Our Ref: DOC20/21200
Your Ref: MP 06_0143 MOD 4

Subject: Glades Estate Residential Subdivision (MP06_0143 MOD 4)

Enclosure: Attachment 1. Detailed Biodiversity and Conservation Comments – Response to Submissions for the Glades Residential Subdivision Moonee Beach

Figure 11: Proposed Additional 31 Allotments

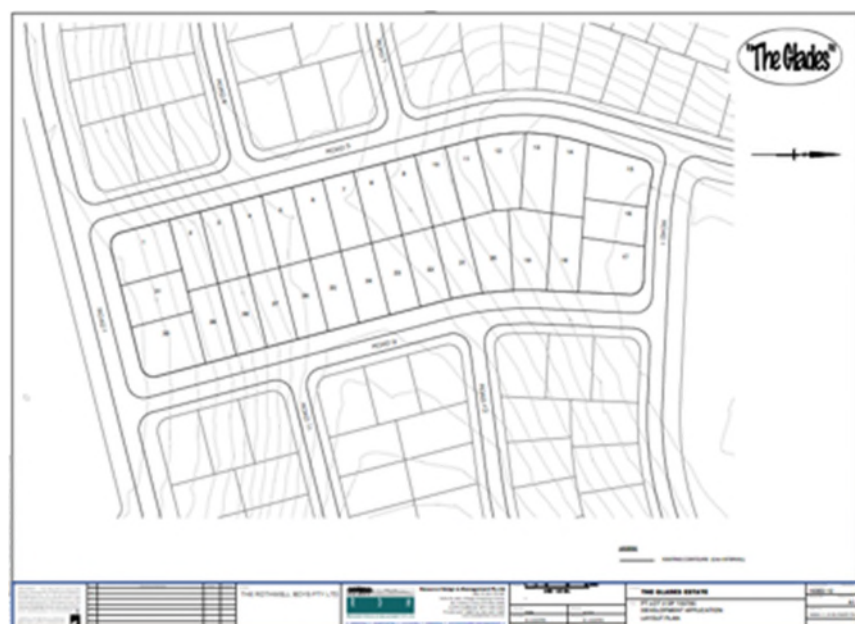
With respect to biodiversity, the RtS does not propose an acceptable additional offset for the loss of the central biodiversity habitat corridor to create the proposed additional 31 residential lots. The RtS does not address the key issue of maintaining adequate north-south habitat connectivity, which was a key consideration in reaching agreement on the design of the approved residential subdivision. In terms of habitat connectivity, the ecological principles that were considered and applied as part of the initial project's assessment remain relevant. The proponent has not responded to the loss of the central corridor by widening the eastern corridor as we previously recommended.

1. The applicant should adjust the subdivision design to increase the width of the eastern habitat corridor so that the impacts of the proposal on habitat connectivity are adequately offset. If this is not achieved, then the modification should be refused. In addressing this recommendation, we recognise that there may be alternative offset configurations that could achieve a wider habitat corridor to the north and east of the development and we would be happy to consider such options.

The RtS does not address the key issue of maintaining adequate north-south habitat connectivity which was a key consideration in reaching agreement on the design of the approved residential subdivision. In terms of habitat connectivity, the ecological principles that were considered and applied as part of the initial project’s assessment remain relevant. The proponent has not responded to the loss of the central corridor by widening the eastern corridor as we recommended.

The BCD recommends that the applicant should adjust the subdivision design to increase the width of the eastern habitat corridor so that the impacts of the proposal on habitat connectivity are adequately offset. If this is not achieved, then the modification should be refused.
